From: Amanda Scholes on behalf of Planning.Responses
Sent: 07 April 2017 08:28
To: Planning Scanning
Subject: FW: Planning Consultation on: BR/45/17/PL

Comments from Environmental Health and Private Sector Housing:

APPLICATION BR/45/17/PL

Description of Works: Variation of condition 2 imposed under BR/270/16/PL relating to approved plans.

Title:-
Proposed Second Floor Plan

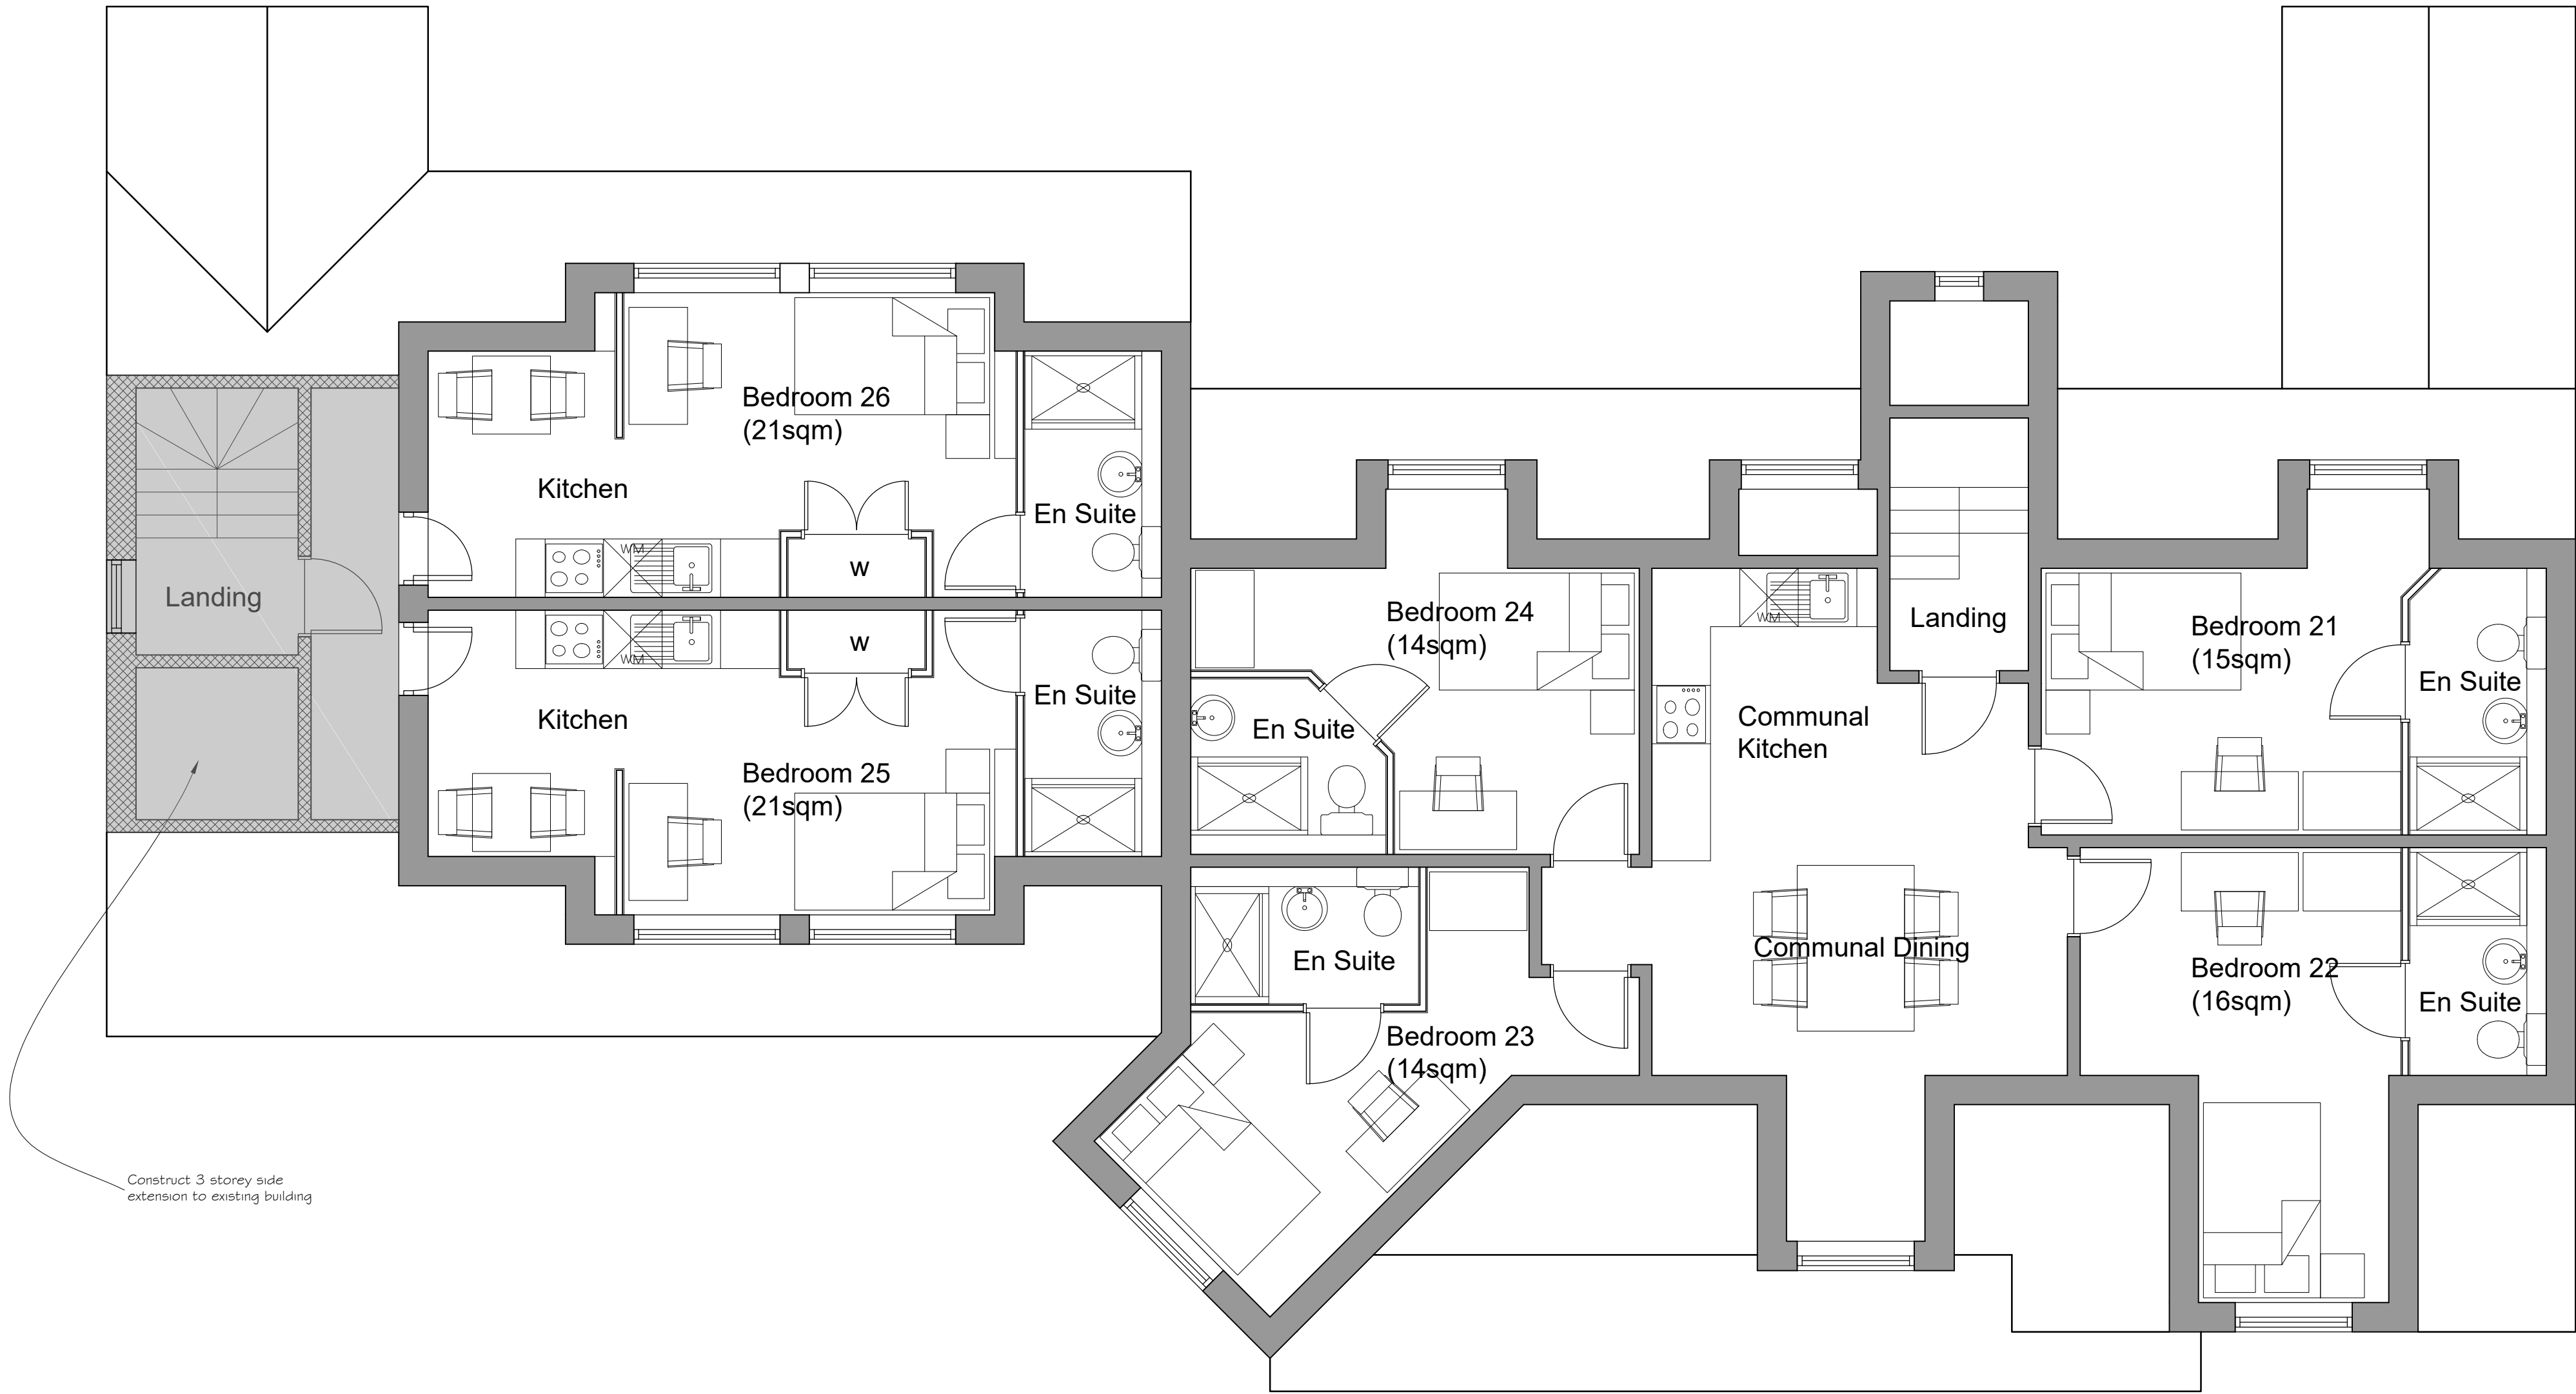
Second Floor

Individual Flats (Bedrooms 21, 22, 23, 24 and 25) - All appears to be satisfactory in terms of layout, room sizes and facilities. My main comment is that all the bedroom areas of the flats have to pass by or through the kitchen area for their escape route in the event of a fire.
